re: **Grading, Site Servicing and Landscaping Review**
 Proposed Residential Development
 1670 Tenth Line Road – Ottawa, Ontario

date: November 5, 2025

file: PG7562-MEMO.01

SHEET NO.:
L1.2

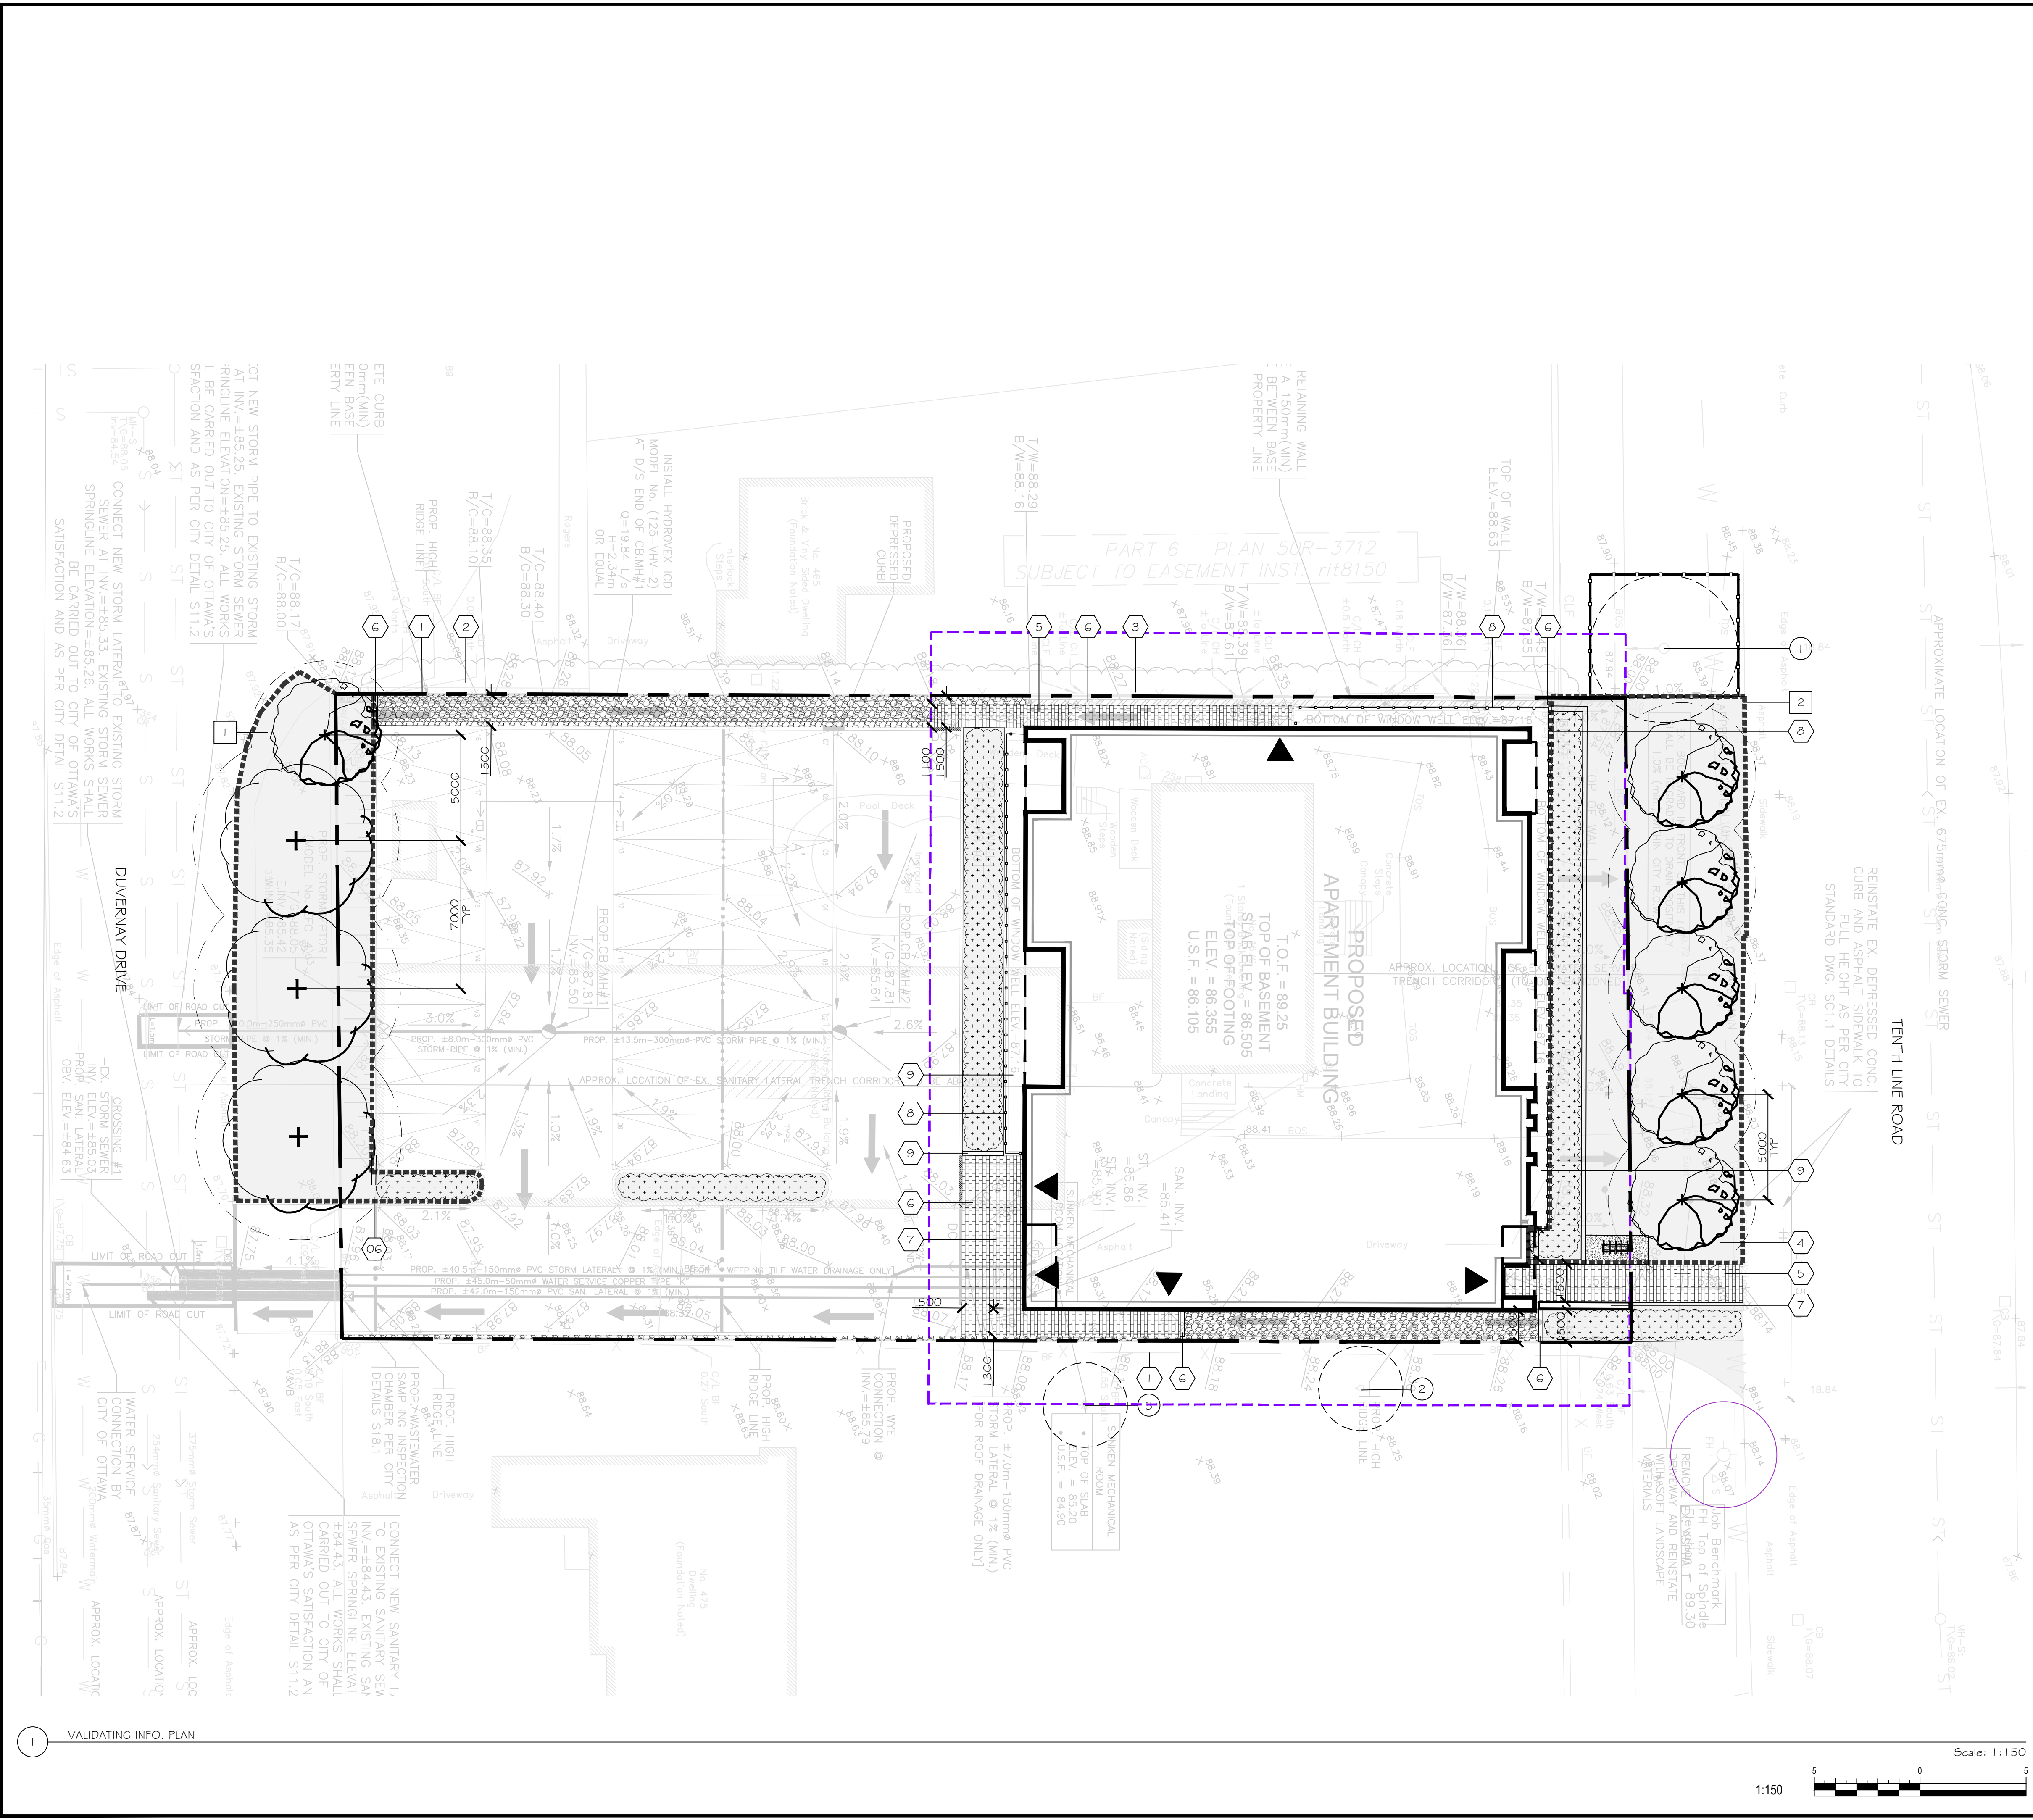
Based recommended in Paterson's review of the landscaping and grading plan, tree planting setbacks of 6.9 to 7.2 m are provided for the front of the proposed building, and tree planting setbacks of 33.0 to 34.5 m are provided for the rear of the proposed buildings. Furthermore, greater than 2.1 m separation is provided between the proposed ground surface and the underside of footing. The landscaping design and tree planting setbacks are considered acceptable from a geotechnical perspective and are in conformance with the recommendations provided in the aforementioned geotechnical investigation report, with respect to the proposed building foundation.

All private services proposed as part of the current development are located at a minimum depth of 2.3 m below the proposed ground surface, which is greater than the tree roots' depth of influence. Therefore, the landscaping design is considered acceptable from a geotechnical perspective and is in conformance with the recommendations provided in the aforementioned geotechnical investigation report, with respect to the proposed building foundation.

It should be noted that the depth of the watermain within the Tenth Line Road right-of-way (ROW) is unknown. However, given Paterson's experience with public watermain and known inverts of nearby watermain, it is assumed that the public watermain within the Tenth Line Road ROW is a minimum of 2.1 m below existing grade. Provided that a minimum separation of 2.1 m between the invert of the watermain and the proposed ground surface is provided, the landscape design is considered acceptable from a geotechnical perspective and is in conformance with the recommendations provided in the aforementioned geotechnical investigation report, with respect to the proposed building foundation. The depth of the watermain invert should be confirmed prior to construction.

6. FOR GRADING AND SERVICING DETAILS OF THIS SITE, REFER TO DWG. No. 825-8, G-1.

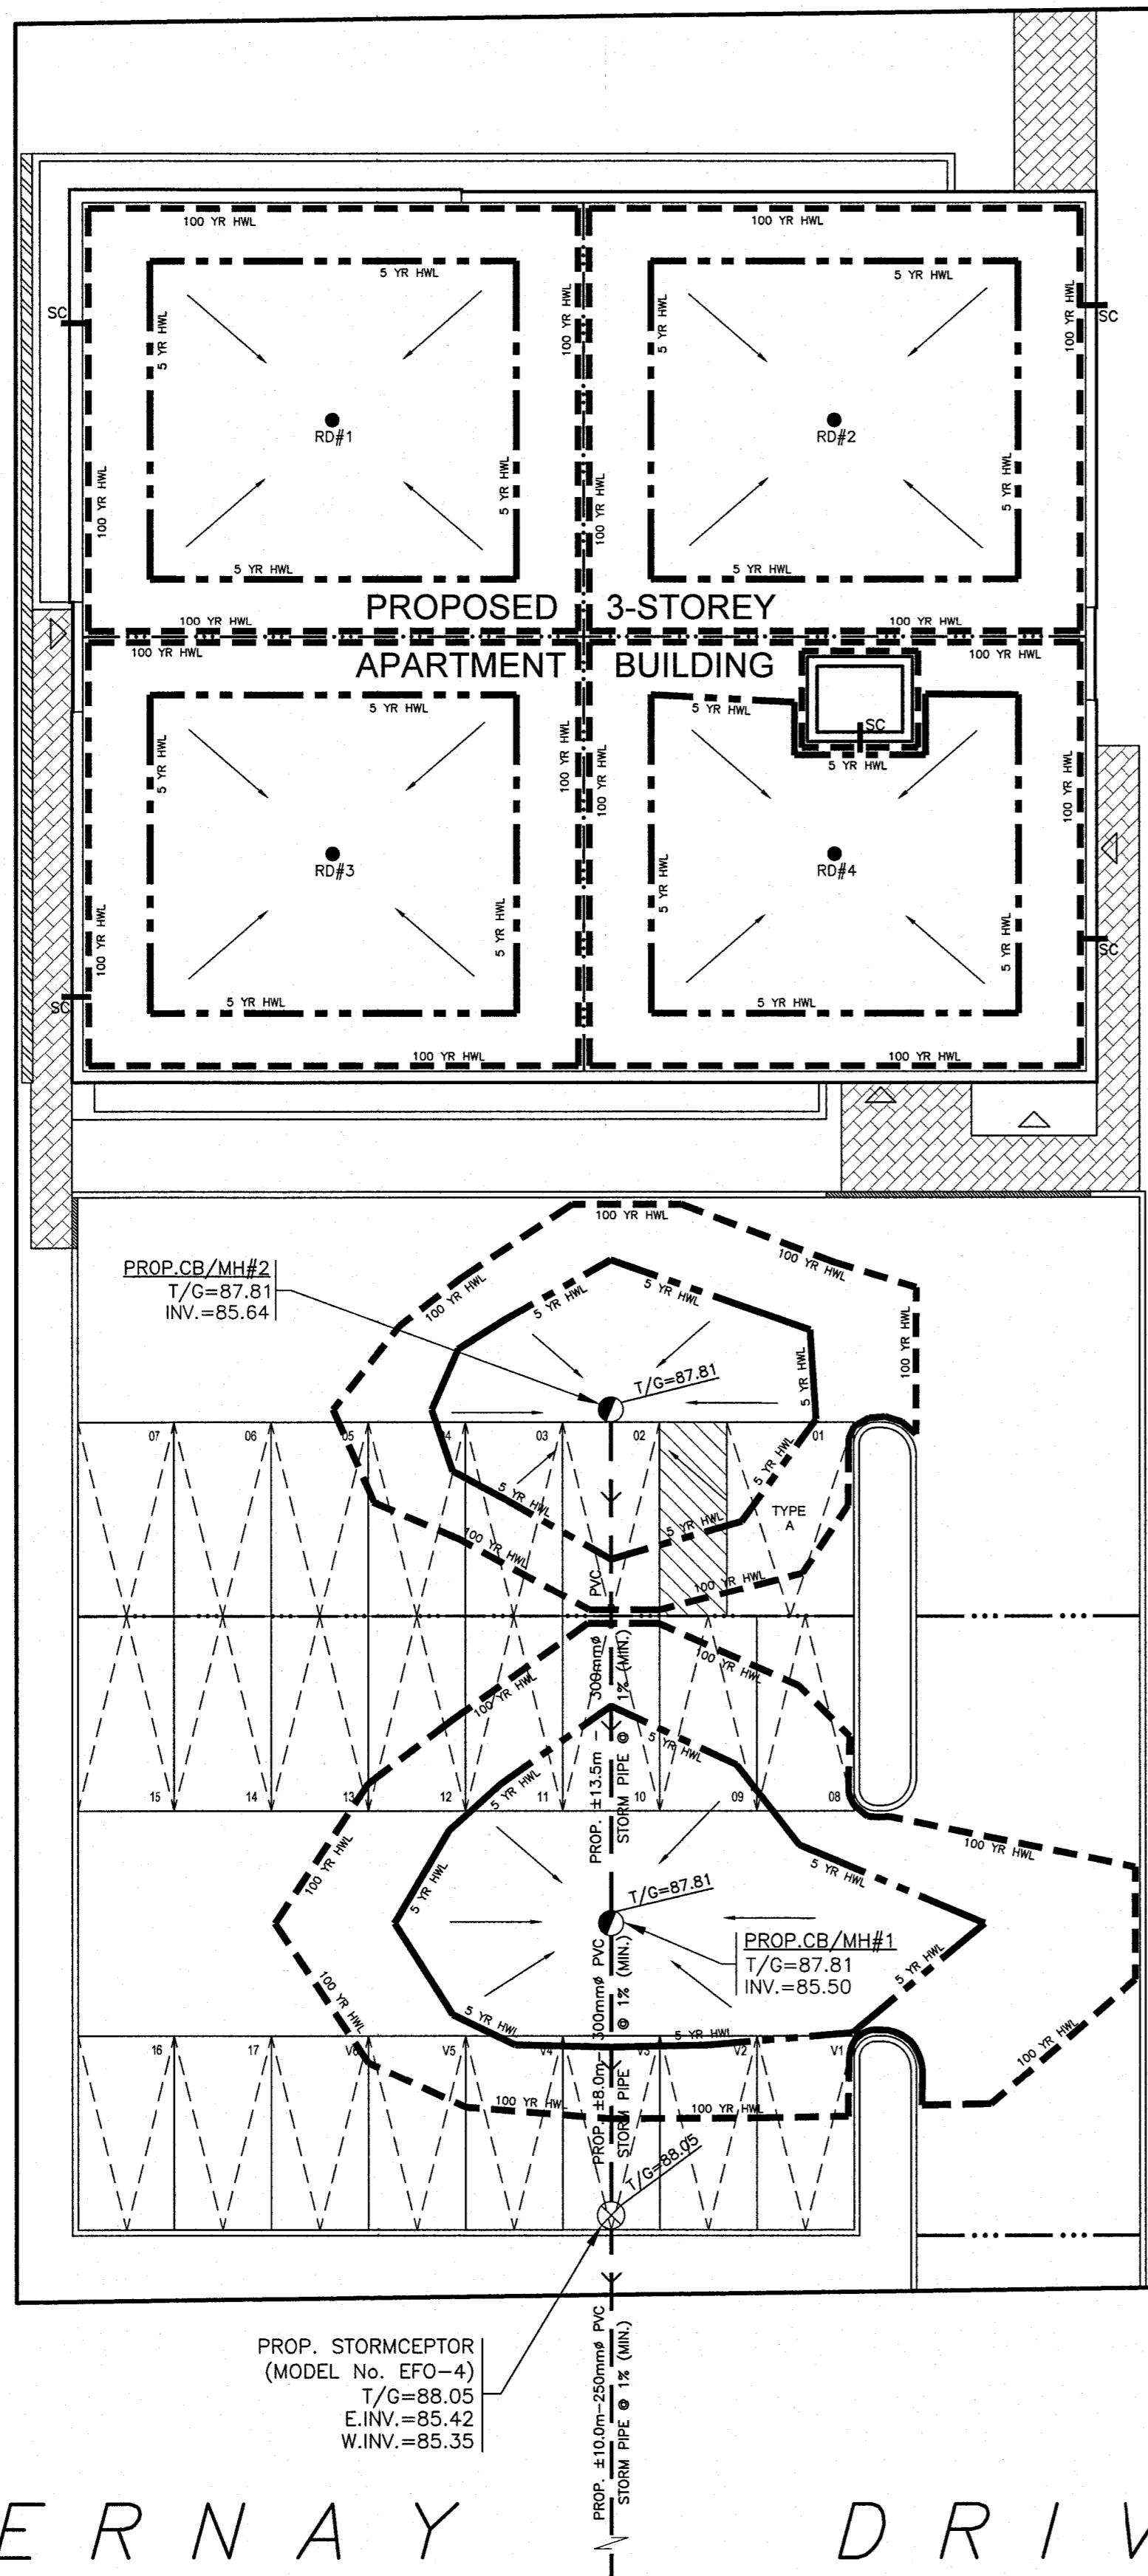
Based on our review of the above noted grading plan, the proposed grade raises within the aforementioned site are acceptable from a geotechnical perspective. The proposed development is not subject to a permissible grade raise restriction. Therefore, lightweight fill is not required for building construction.

Based on our review of the grading plan, it is expected that the proposed underside of footing (USF) elevation will primarily be 86.105 m. Upon reviewing the subsurface profile according to the completed boreholes, the majority of footings will be founded within hard to stiff, brown silty clay. If the USF is kept as per the grading plans, a bearing resistance value of **125 kPa (SLS)** and **200 kPa (ULS)** should be utilized for the proposed footing design.

However, it is understood that a sunken mechanical room is proposed within the southern corner of the proposed building, with a USF of 84.90 m, placing the footings for the mechanical room within stiff to firm, grey silty clay.

Based on our review of above noted grading plan, the perimeter footings for the proposed development are provided with sufficient soil cover for frost protection. Therefore, rigid insulation will not be required.

Based on our review of the aforementioned site service plan, all services will be constructed outside the lateral zones of the proposed footings of the building and are acceptable from a geotechnical perspective.

Based on our review of the aforementioned service plan, all storm and sanitary services for the proposed development have been provided sufficient soil cover for frost protection. Therefore, rigid insulation will not be required.

It should be noted that the invert elevation of the watermain pipe has not been presented in the aforementioned site servicing drawing. Given the depth of the mechanical room, it is anticipated that sufficient soil cover for frost protection will be provided. However, if insufficient soil cover is provided for the watermain pipe, rigid insulation should be installed as recommended in Table 1 on the following page.

Therefore, the footings for the mechanical room should be designed using a bearing resistance value of **80 kPa (SLS) and 120 kPa (ULS)**. The bearing resistance values are required to be verified in the field.
